STERLING RANCH EAST FILING 5 PRELIMINARY PLAN

LETTER OF INTENT

AUGUST 2023

Please see comments provided by engineering on the Letter of Intent for Sterling Ranch East Filing 5, P237, and update accordingly.

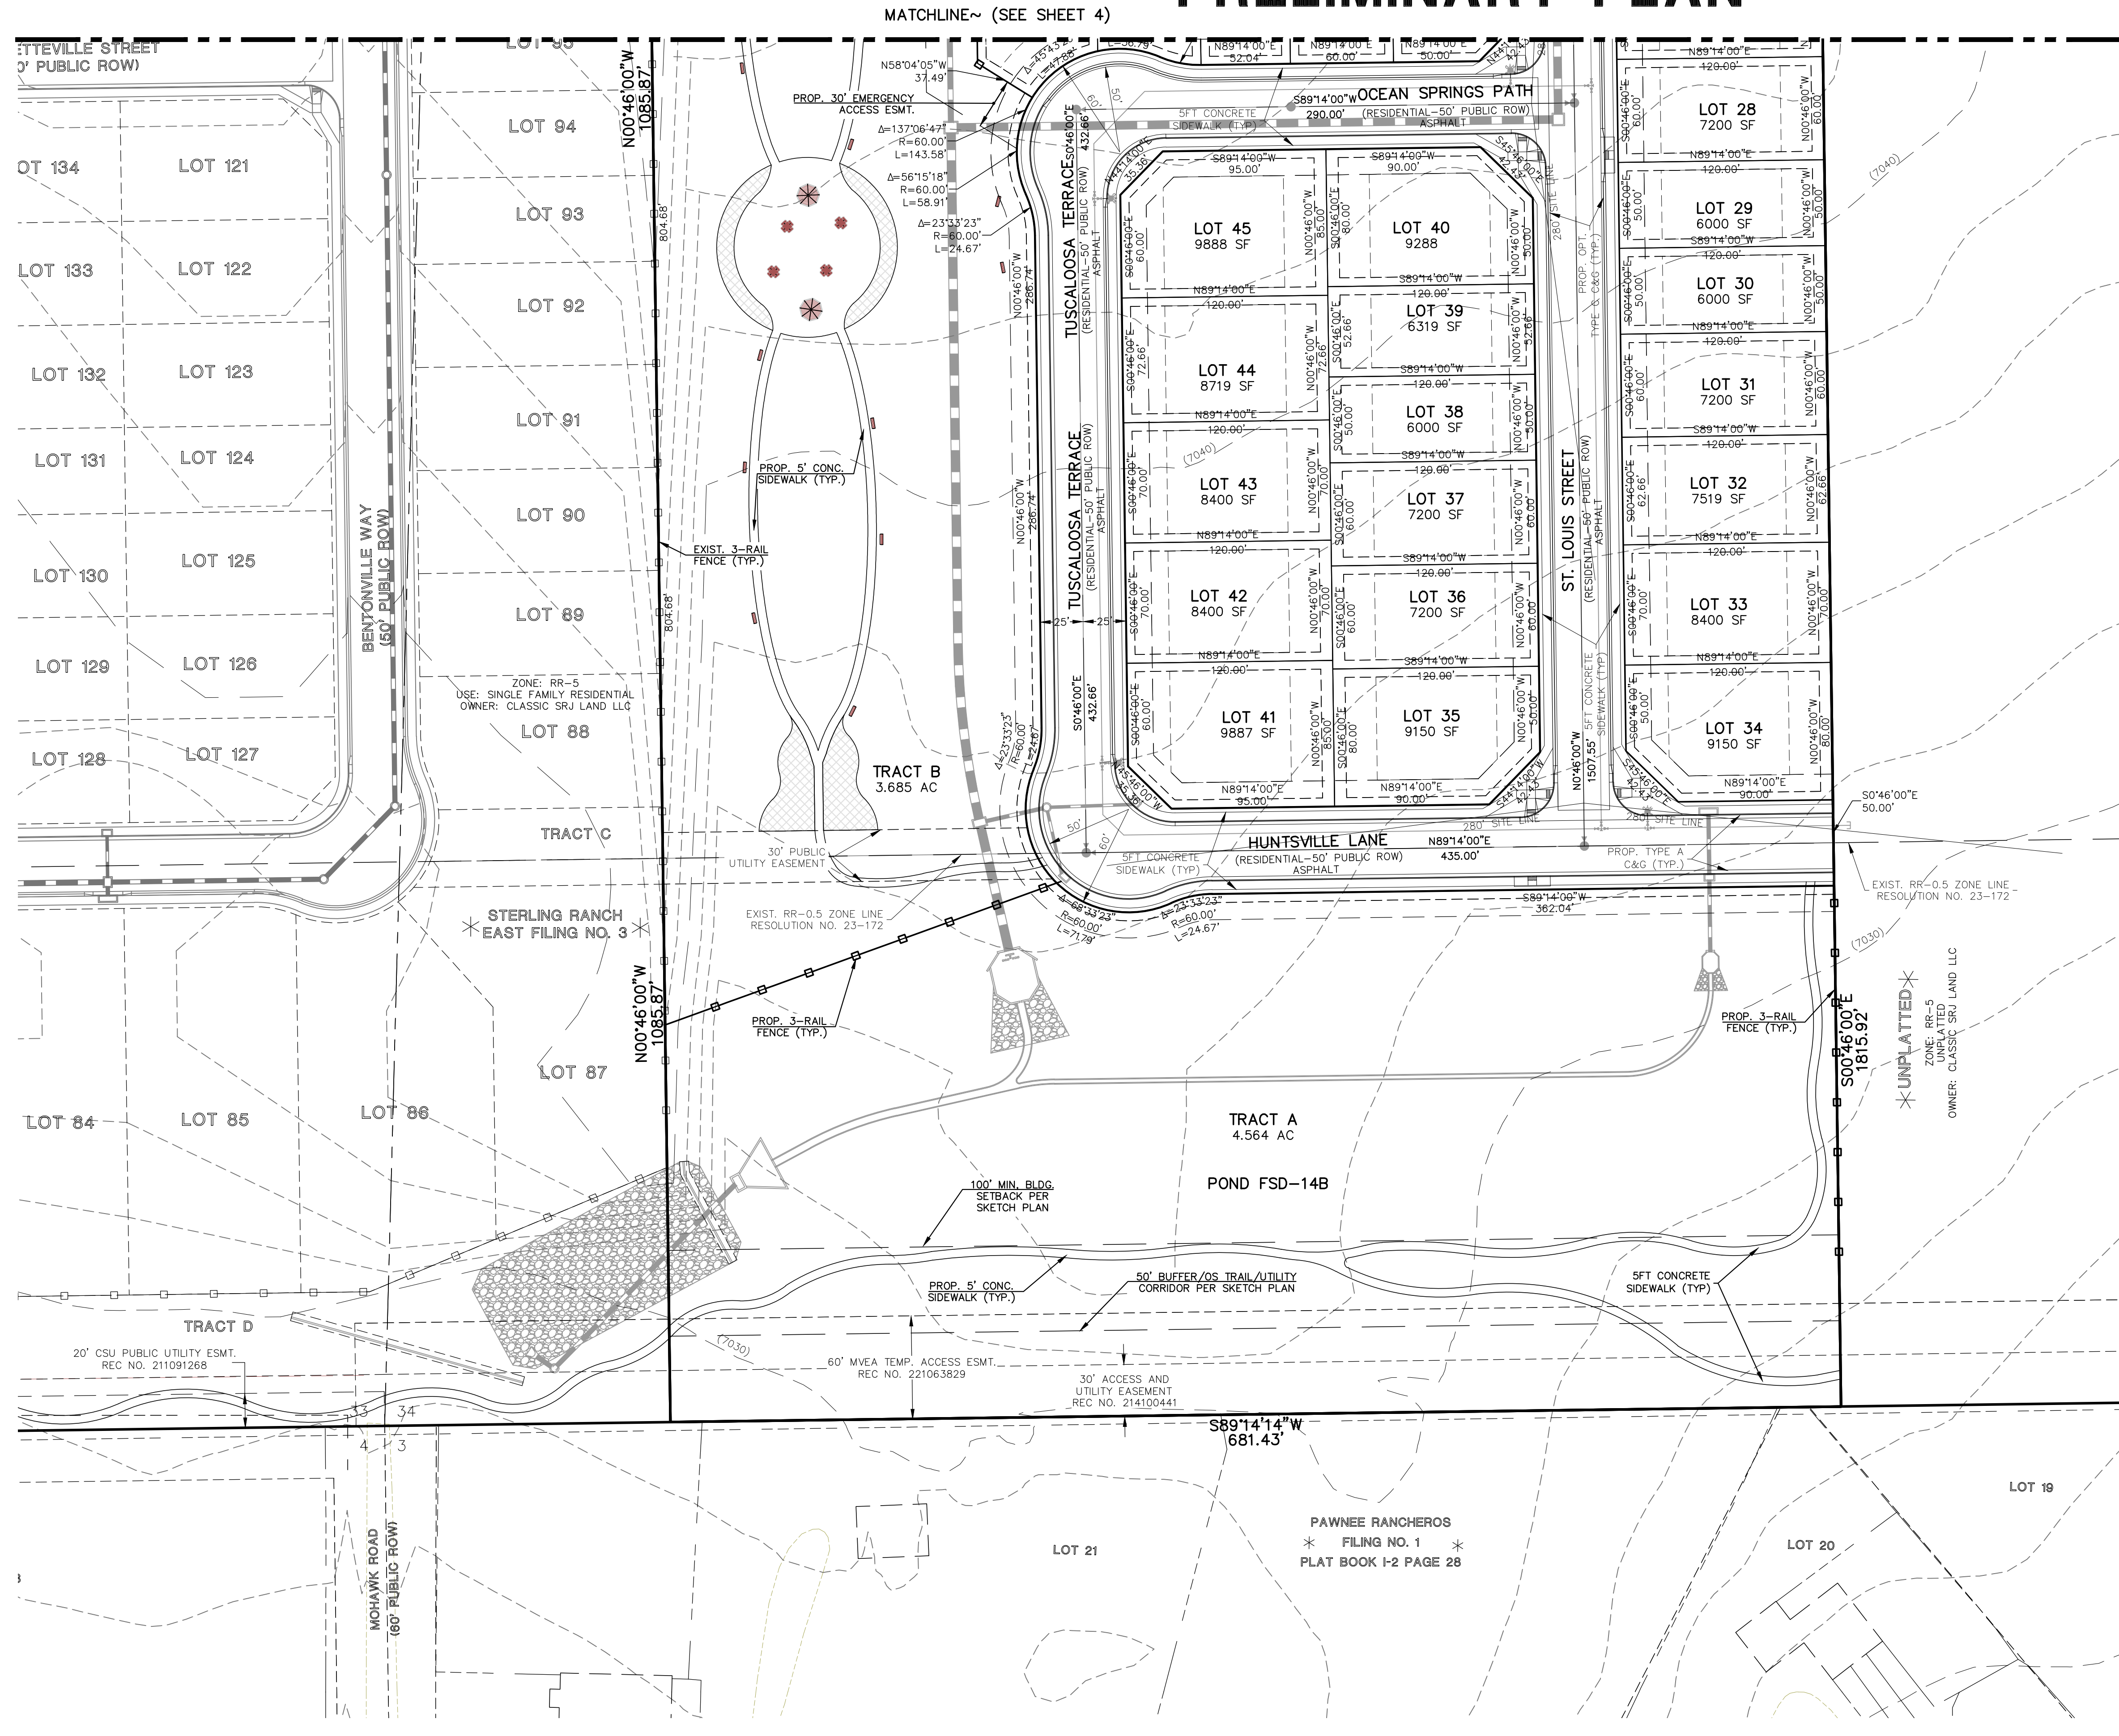
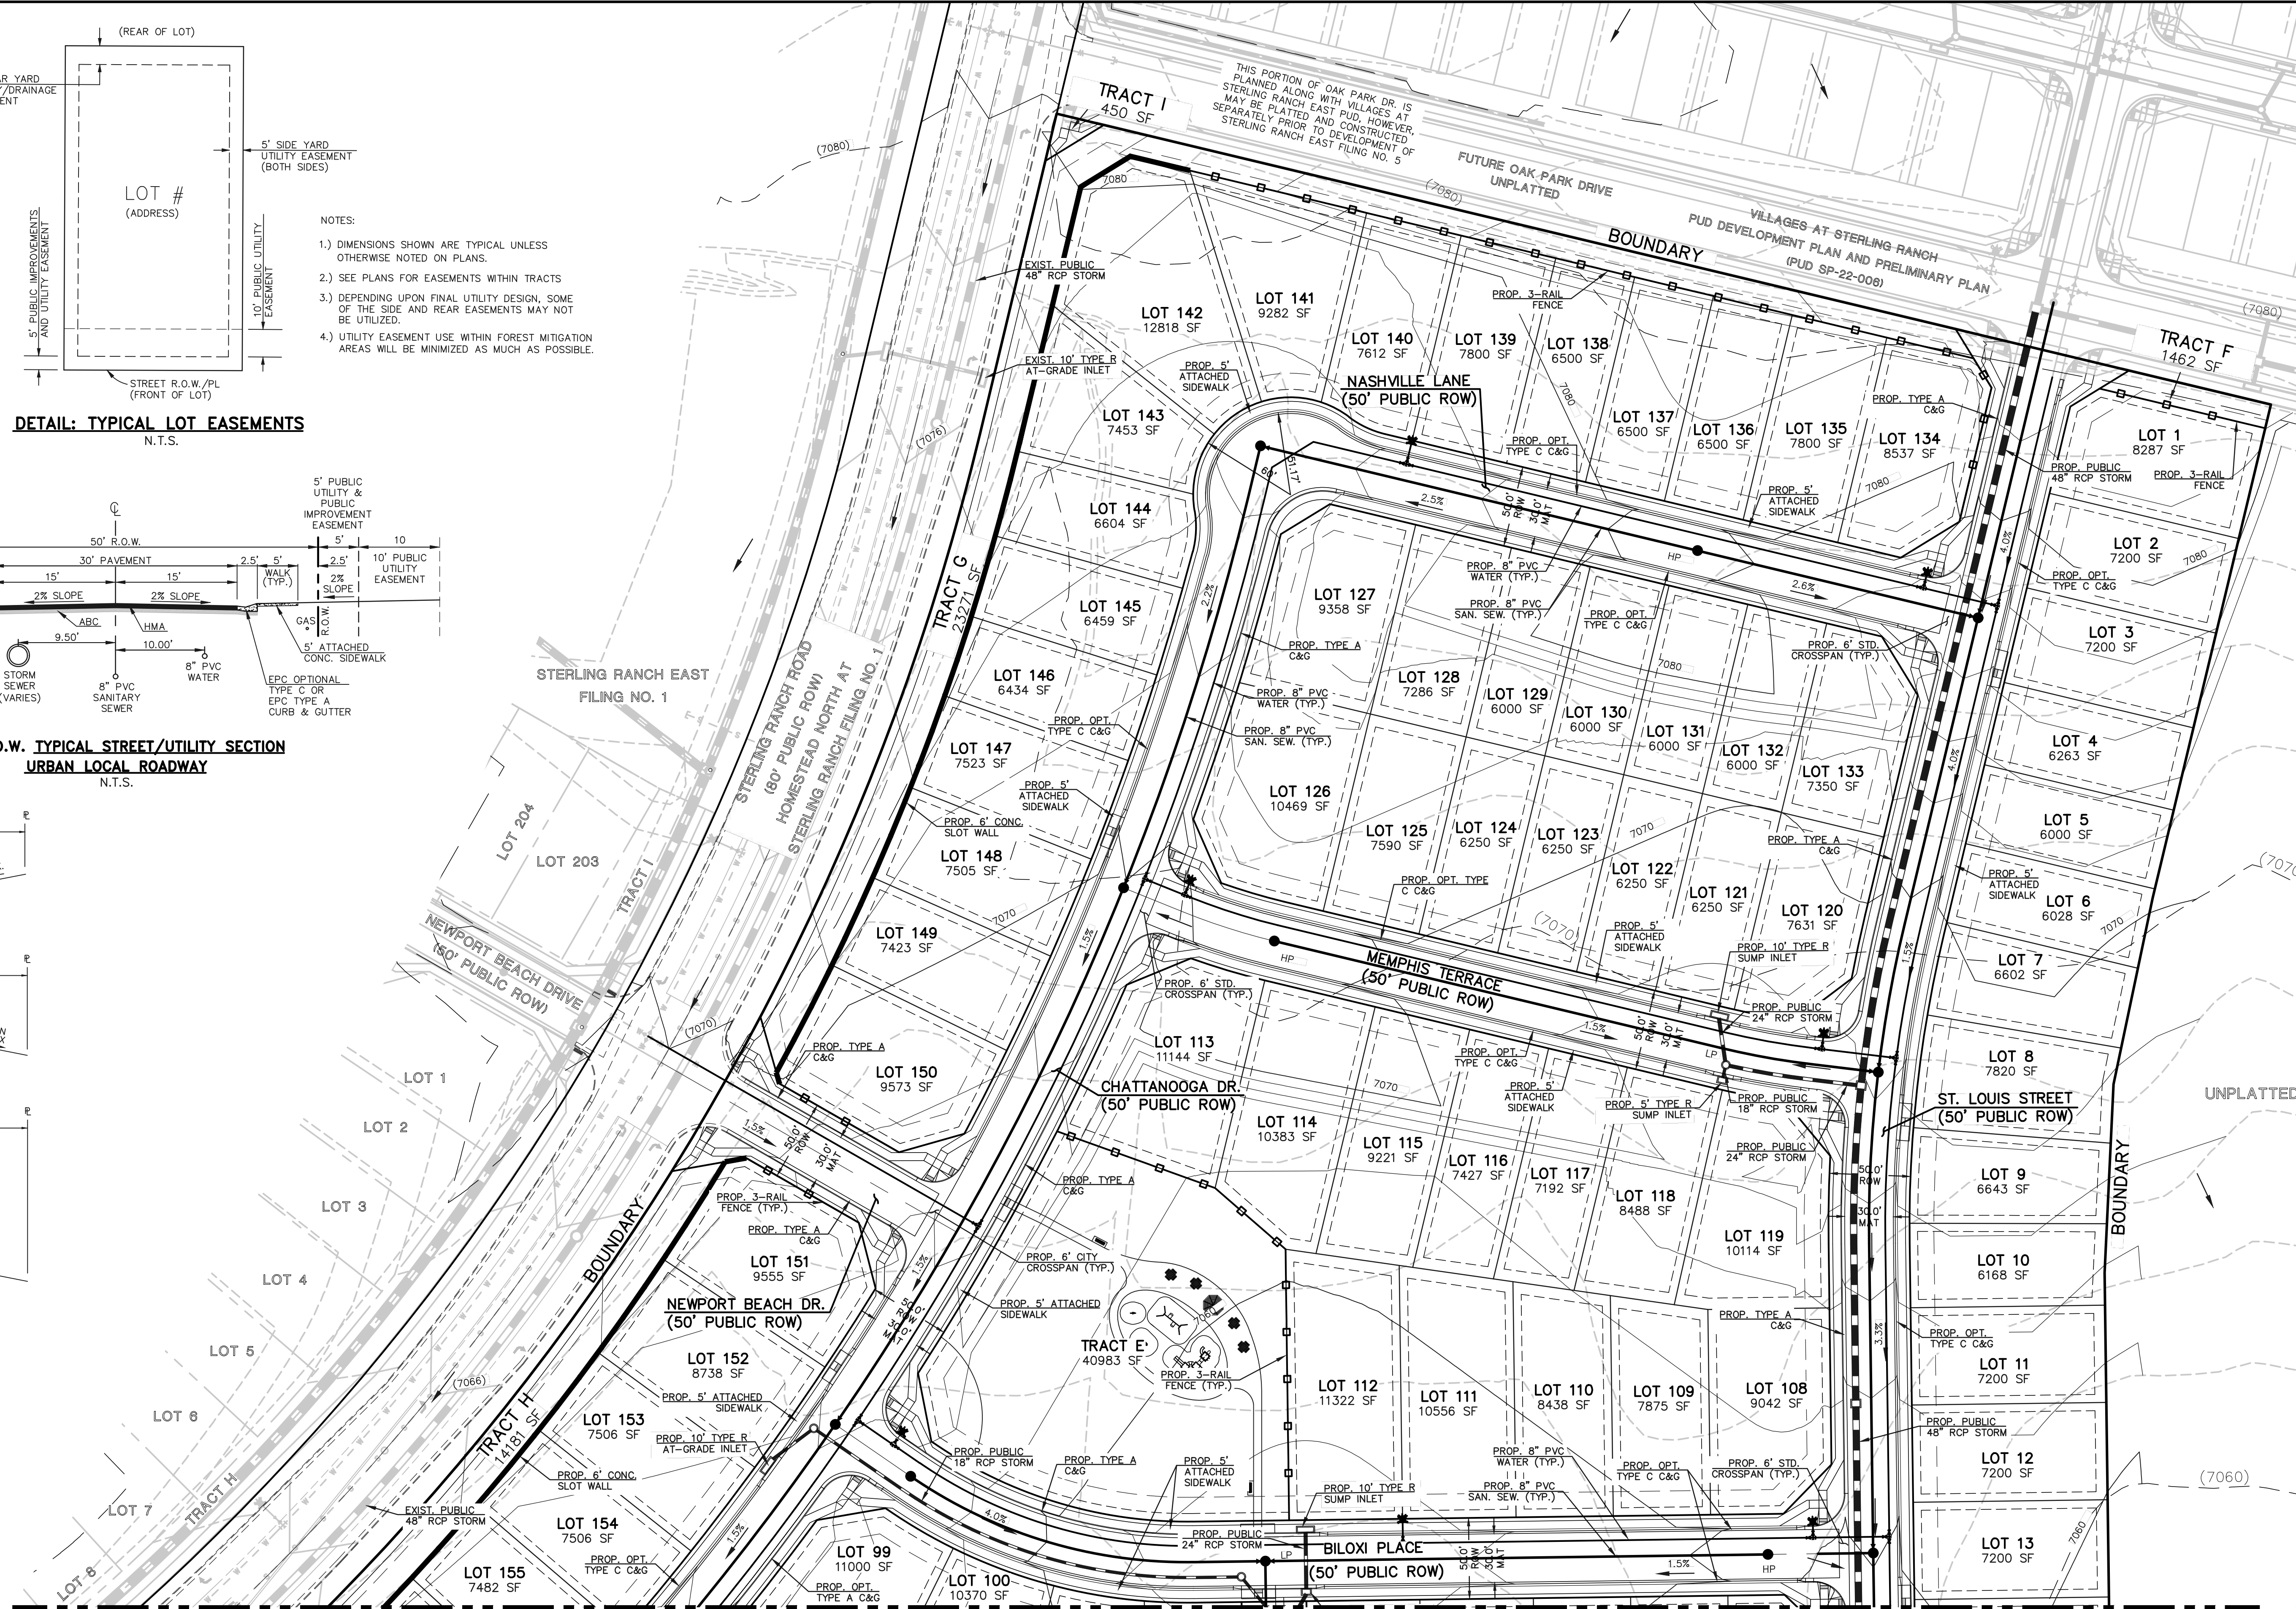
Sterling Ranch Road does not require noise mitigation as it is classified as a collector, but the 6' concrete panel noise wall is continued along Sterling Ranch Road screening for privacy and to provide a consistent development identify. A detail of the 6' concrete panel wall is provided in the preliminary plan set (sheet 18).
